Subject: RE: Planning Consultation on: AL/52/20/PL

Application No: AL/52/20/PL

Site Address: North Cottage Arundel Road Aldingbourne PO18 0JX

Description of Works: Erection of a block of 3 stables. This application is in CIL Zone 3 (Zero Rated) as 'other development'.

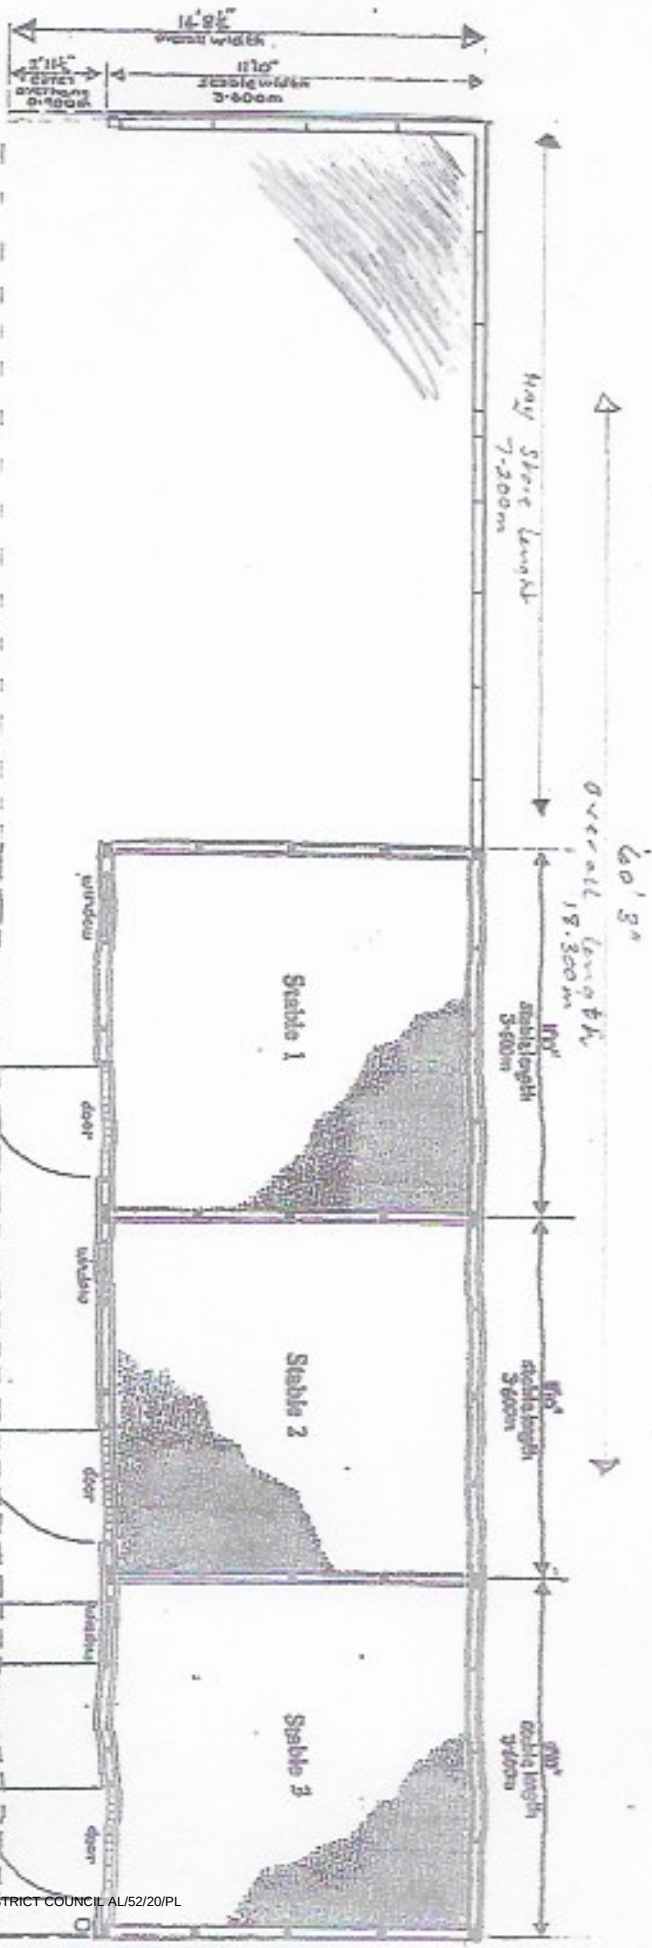
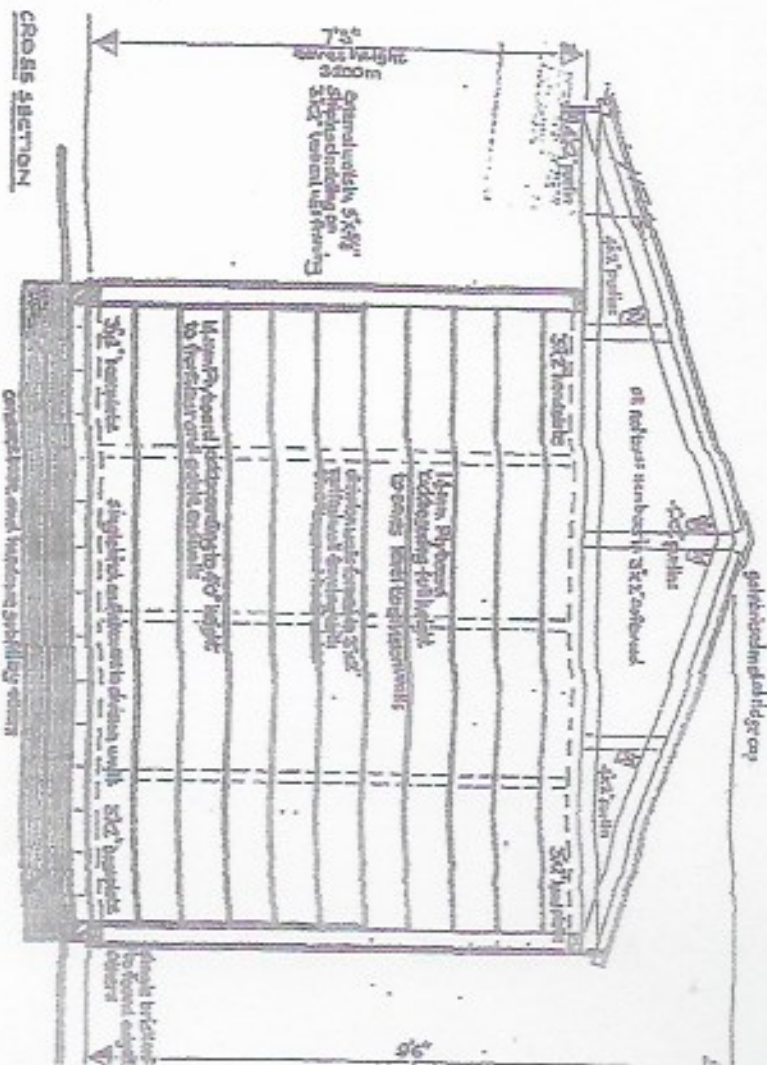
I do note that water butts are proposed for water re-use. The applicant should consider installing formal overflows from the butts (to deal with flows when they are full) to perhaps shallow soakaways. No surface water should be discharged to the foul drainage system ie. septic tank.
